CITY OF ALBUQUERQUE

February 14, 2022

Re: Reflective Auto Collision
801 Gibson Blvd. SE
Traffic Circulation Layout
Architect's Stamp 12-03-2021 (L14-D061)

Based upon the information provided in your submittal received 2-9-2022, the above referenced plan cannot be approved for Building Permit until the following comments are addressed:

TRAFFIC CIRCULATION LAYOUT

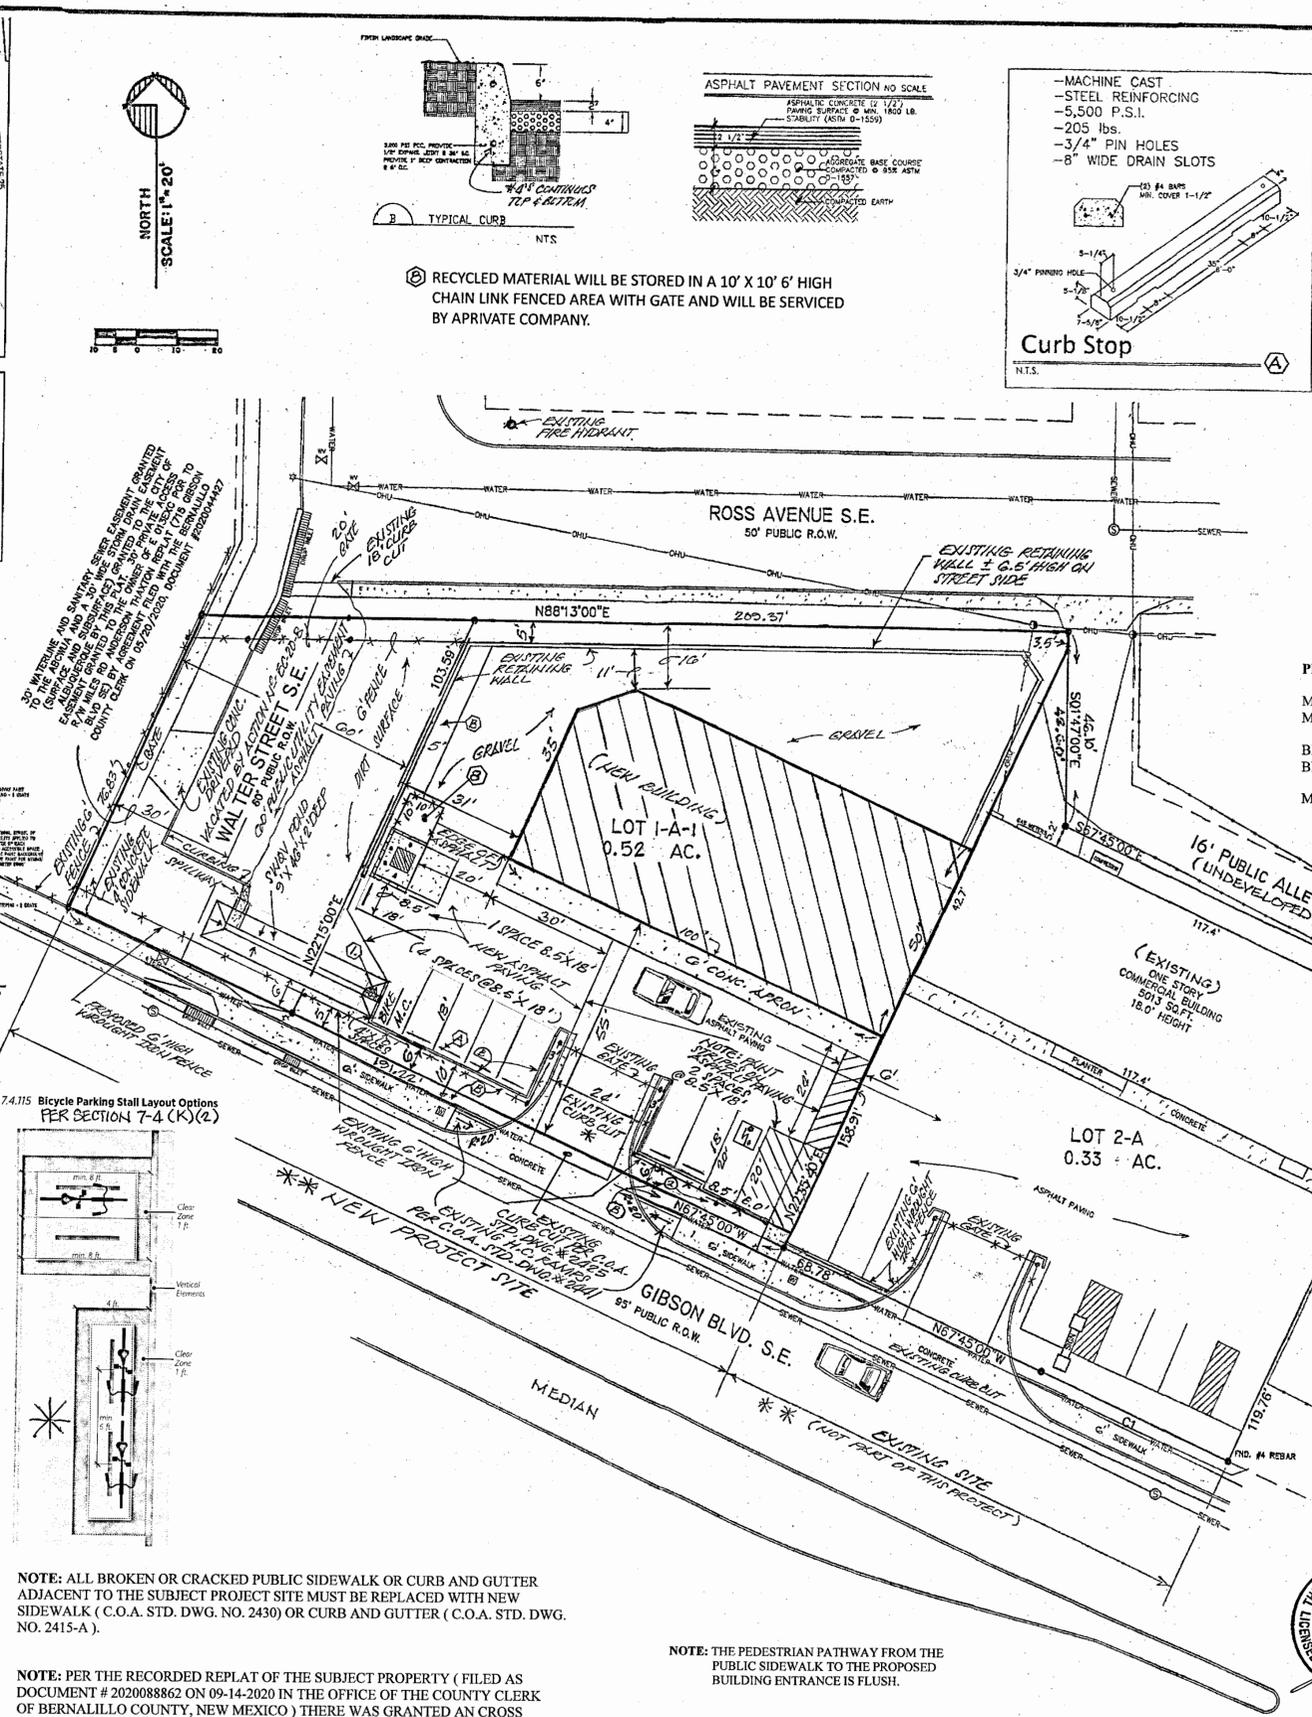
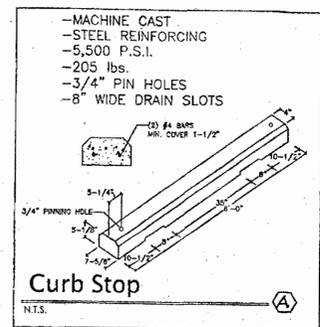
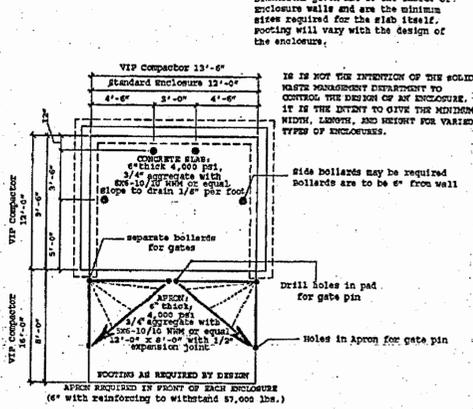
1. List the number of Motorcycle and Bicycle parking spaces required by the IDO.
2. The ADA accessible spaces must include an access aisle. Van accessible aisles should be 8ft wide; all others should be 5ft wide.

3. Please indicate if the pedestrian pathway from public sidewalk to the building entrance is flush or there is an ADA ramp? If so, please provide ramp details.

4. property line should not be placed on a parking space.
5. Provide shared parking agreement with the adjacent property on the east side of your site.
6. Provide more details about existing driveway entrance, and call out COA std dwg.

7. Add a note stating "All broken or cracked sidewalk must be replaced with sidewalk and curb & gutter." A build note must be provided referring to the appropriate City Standard drawing.
